Reviewed by
dsdgrimm
04/30/2019 2:15:54 PM

7750 MOHAWK ROAD
LOT 2, BL 2 PAWNEE
RANCHEROS FILING 1

7750 MOHAWK ROAD
LOT 2, BL. 2 PALUNISE
RANCHEROS FILING 1
Legal description

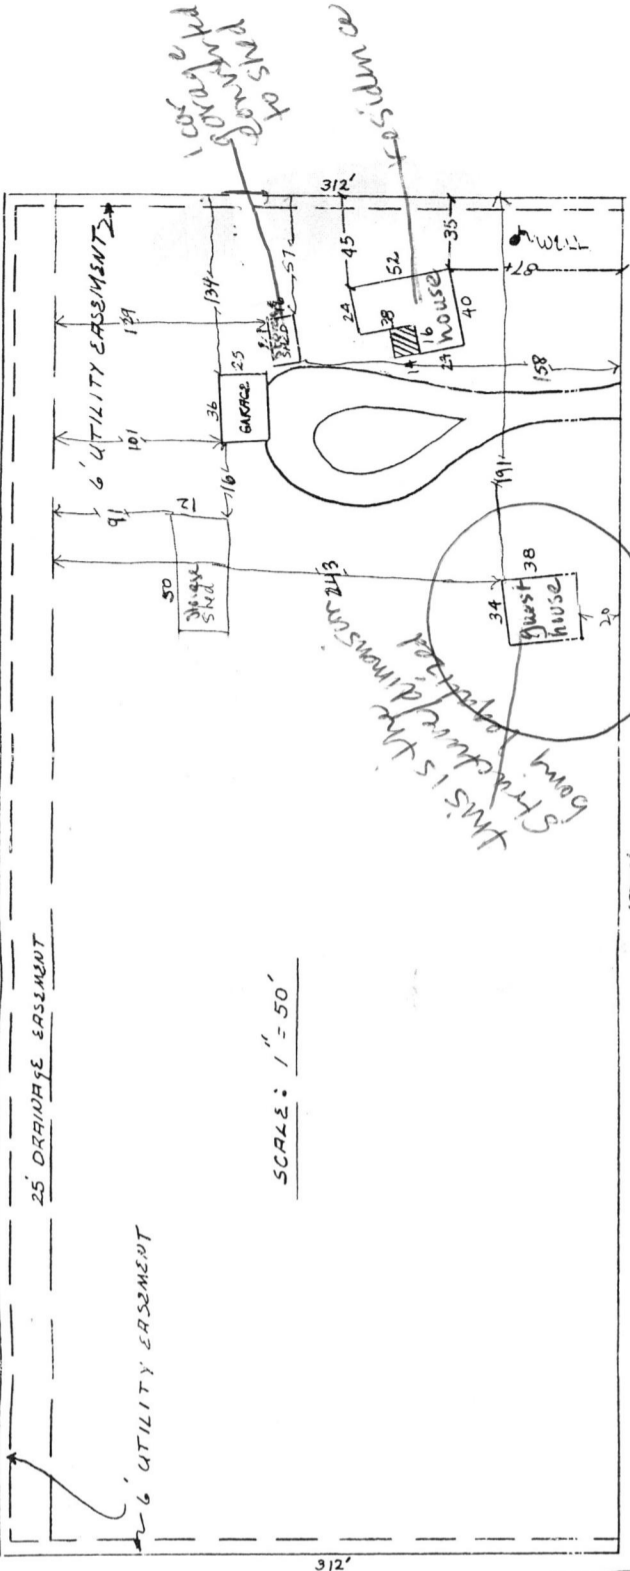
Identify this line as the
property boundary

please show as
residence

only 1 guest house is
allowed. Please
relabel if this is being
removed/converted

Identify structures
as existing or
proposed.

Identify if the barn
uses the existing
access location or if a
secondary access
location is proposed.

please identify this as
the
structure/dimension
being legalized
